**From:** Dave McGuire <Dave.McGuire@sportengland.org>  
**Sent:** 04 July 2023 16:51  
**To:** DCAdmin; William Simcock  
**Subject:** 2023/91704 Prior notification for proposed 20m high Valmont climbable monopole  
ALMONDBURY CRICKET CLUB, ALMONDBURY CRICKET CLUB FERNSIDE AVENUE, A... HD5 8NU

The proposal impacts on the playing field in two ways. Firstly through the construction of the access road, and secondly through the siting of the monopole and enclosure.

Title: **004 LEASE DEMISE**

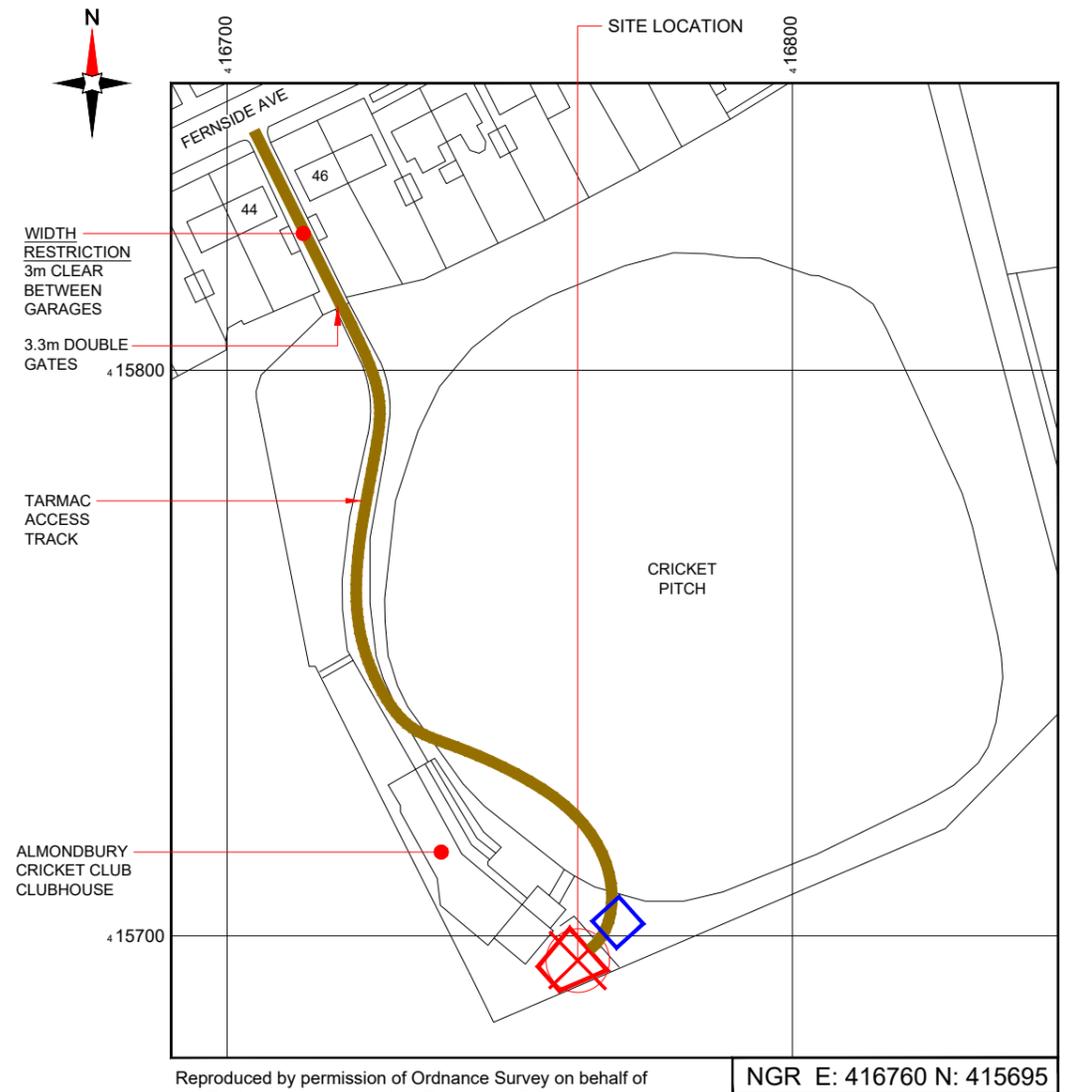
The proposed monopole is located on the periphery of the playing field, and Sport England is satisfied that it meets the exception’s requirements. The tarmac access route to the monopole will significantly encroach onto the playing area outfield of the cricket pitch. It is unclear from the application detail whether the access route is a temporary or permanent measure. Either scenario would be contrary to playing field policy exception 3. It would also prejudice the continued use of the cricket pitch. A permanent loss of the cricket pitch outfield would therefore encounter an objection from Sport England that would seem impossible to resolve. If however the access route were temporary, the work carried out then properly remediated during the close season then it might be possible for Sport England not to object.

Title: **003 ACCESS PLAN**

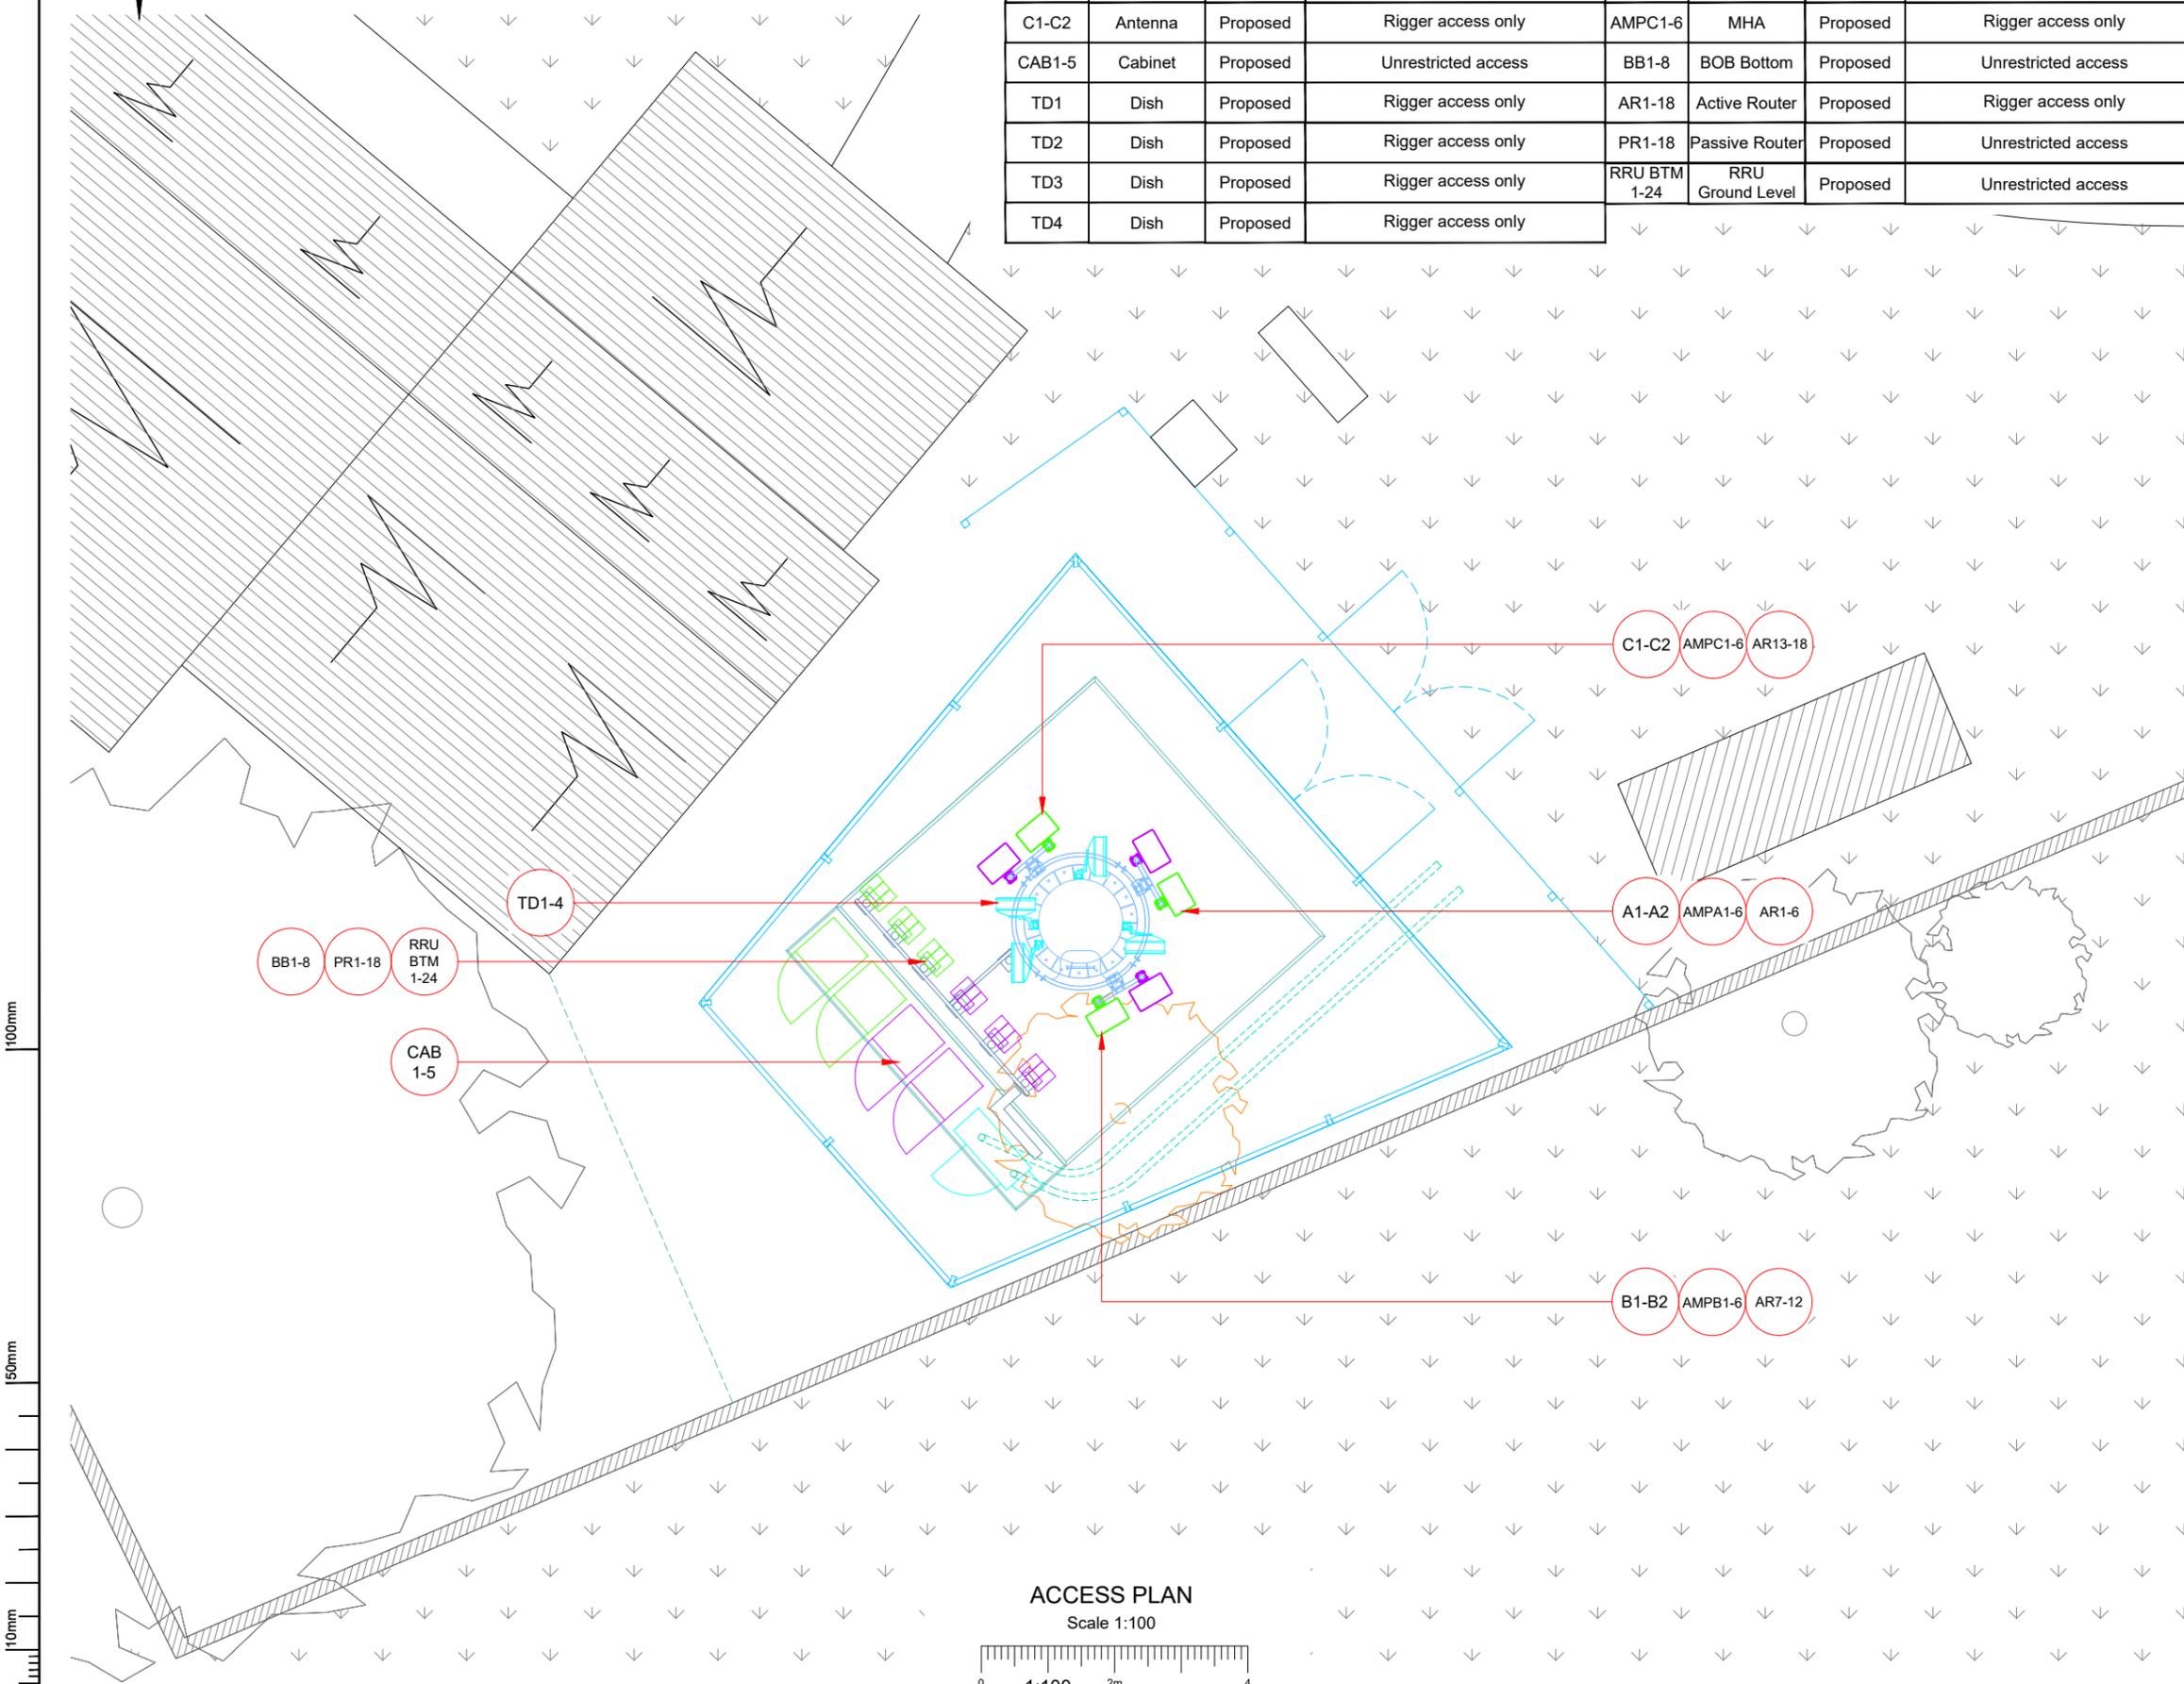
In light of the above, Sport England **objects** to the application because the proposed access road is not considered to accord with any of the exceptions to Sport England’s Playing Fields Policy or with Paragraph 99 of the NPPF.
